From: Amanda Scholes on behalf of Planning.Responses
Sent: 09 June 2020 10:23
To: Planning Scanning
Subject: FW: A/80/20/NMA Land between New Place Nursey and Arundel Road, Angmering
Attachments: 1917-PL-358 Type 3 Comparative elevations.pdf; 1917-PL-150A Proposed Site Layout (Comparative Layout).pdf

From: Ainara Goikoetxea [REDACTED] <[REDACTED]>
Sent: 08 June 2020 18:22
To: Anita Gardner [REDACTED]
Subject: Re: A/80/20/NMA Land between New Place Nursey and Arundel Road, Angmering

Please find attached the amended site plan in which I have overlapped previous approved application's layout and the new proposed site layout for comparison and to look at the House Type 3 in relation to the boundaries.

TITLE:
TYPE 3 - PROPOSED
GROUND FLOOR PLAN

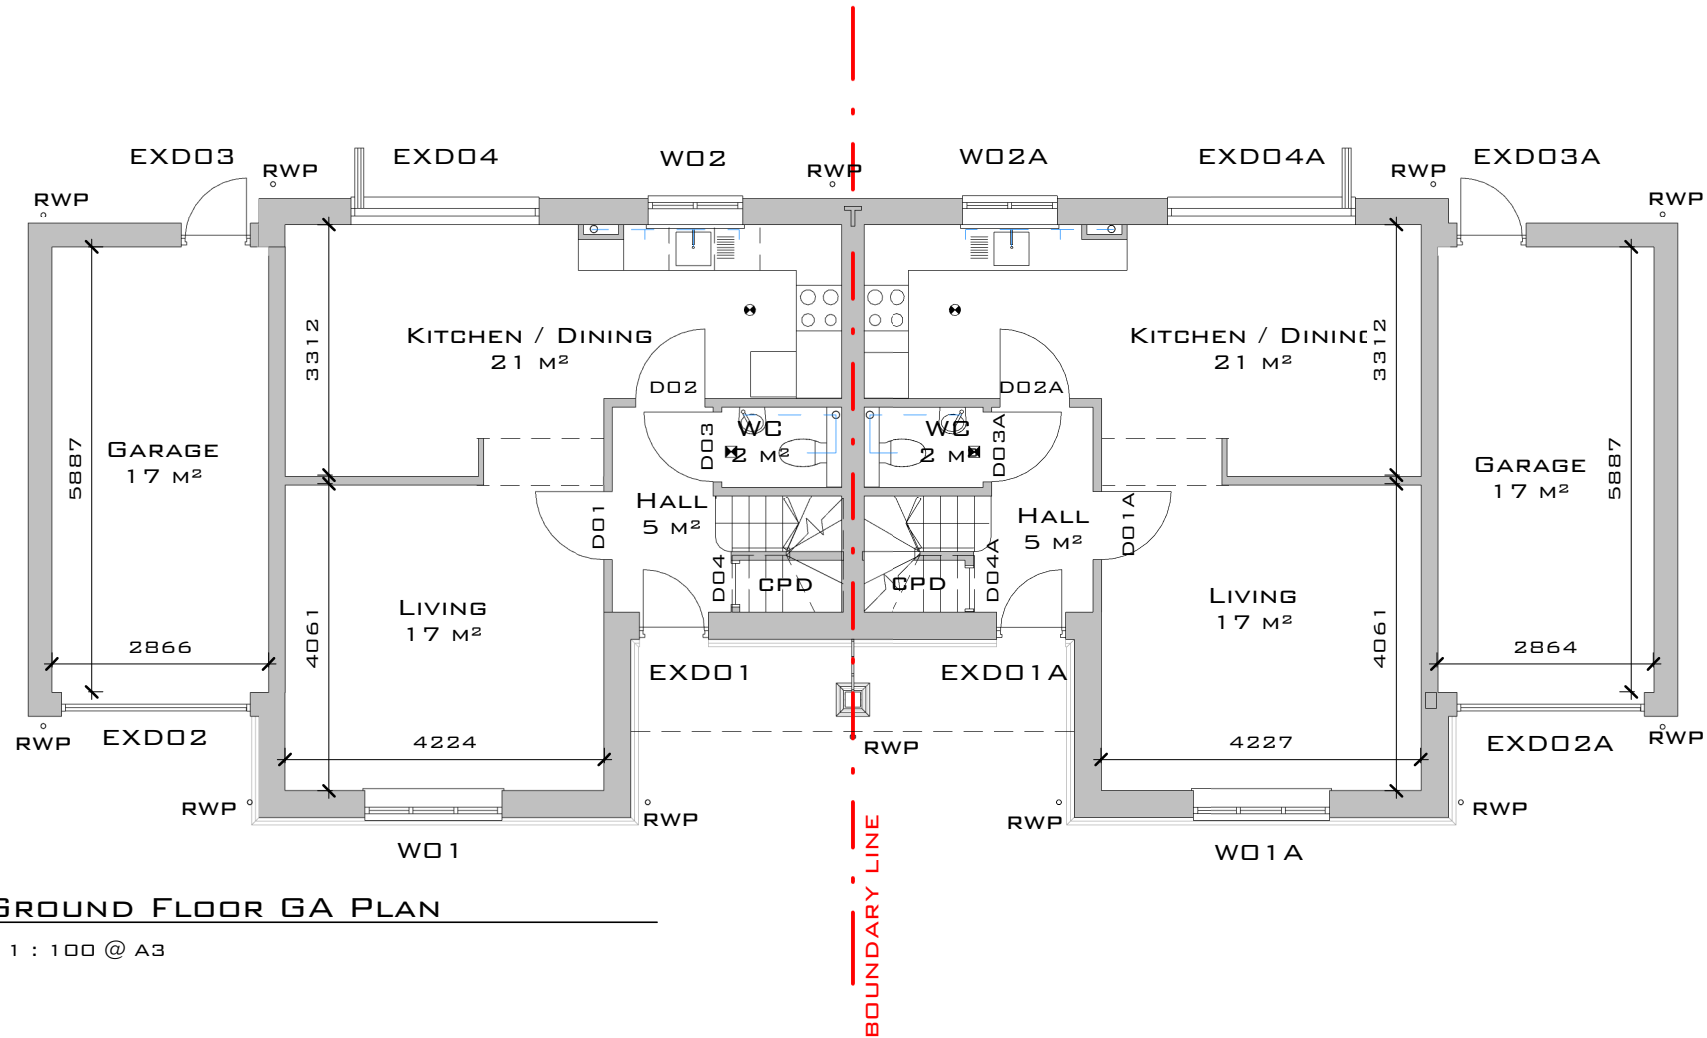
I have received the above application today. In order to progress your application promptly I would appreciate clarification of the changes to the footprint of the dwelling proposed. At the moment I am unable to print plans and scaling from the website is not very accurate. Please can you confirm which plots numbers are affected (I assume it is plots 5 and 6), details of the differences in ridge height (this appears to be 0.7m higher) and dwelling width (appears to be 0.7m wider) and a comparative layout plan of the approved dwelling in relation to the plot boundaries. It looks as though plot 6 is now positioned on the boundary and has been moved towards the rear of the site.

I confirm that the affected Plots are 5 & 6 in our drawings.

Plot 6 boundary fence has been moved to allow access to the garden.
